Morgan and Morecambe Offshore Wind Farms Transmission Assets DCO Application

PINS Reference EN020032

Newton-with-Clifton and Freckleton Parish Councils

Written Representation and Summary of Case at ISH1

**Figure 1.2: Biodiversity Benefit Area at Lea Marsh**

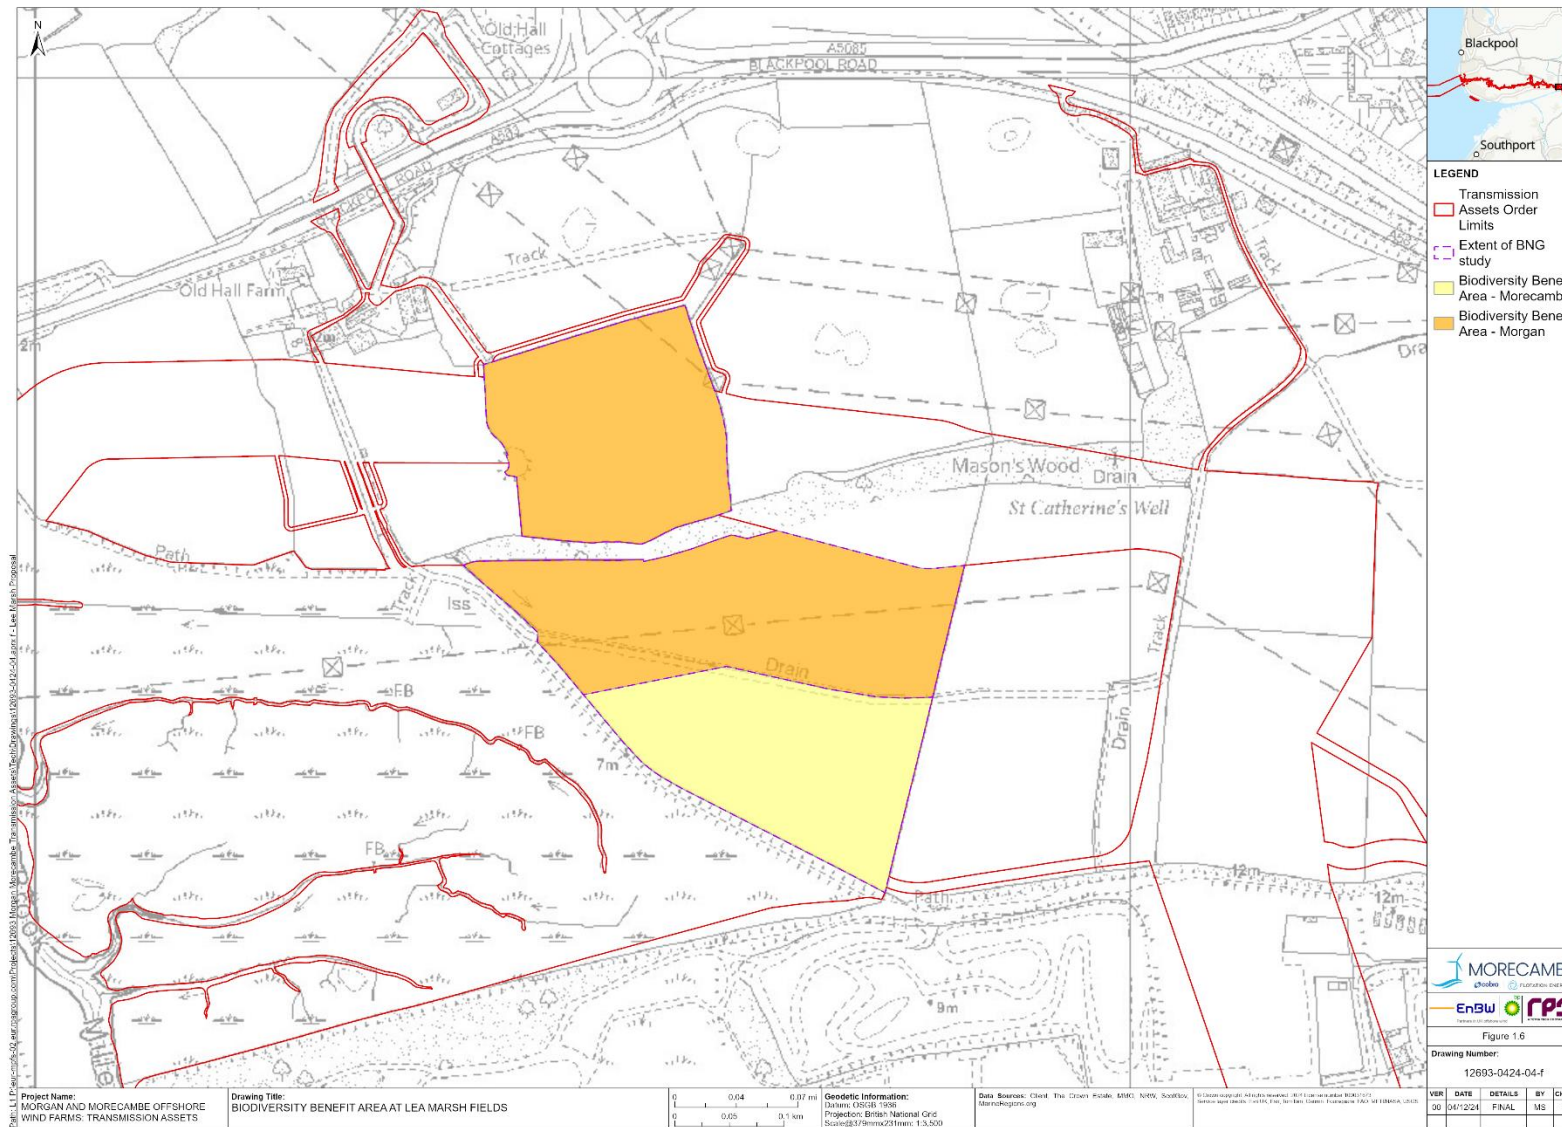
As was heard at the hearing (or at least not disputed when questioned by the Examining Authority), the Applicants have failed to assess the proposed environmental enhancement area at Lea Marsh Fields for increased risk of bird strike at Blackpool Airport and Warton Aerodrome and the project may therefore either add an unacceptable risk to human life or if it reduces the enhancement area, not provide adequate ecological mitigation. The proposal only assesses lost habitat at the proposed permanent infrastructure and not along the cable route, when (page 34 of) [biodiversity rules](#) require the inclusion of habitat that will not be fully restored to its original type and condition within two years of being impacted, so biodiversity losses are being significantly under-reported and therefore 10% gain is not being provided.

Any reduction in the quality of (the permanent) habitat at Newton March, Lytham Moss, Freckleton Marsh and Lea Marsh to discourage birds from visiting it will have a consequential effect on the biodiversity score so it may not be possible to satisfy BNG requirements (admittedly not yet a legal obligation but recommended in policy) and avoid increasing bird strike risk. The proposed habitat can be found on page 56 of APP-106
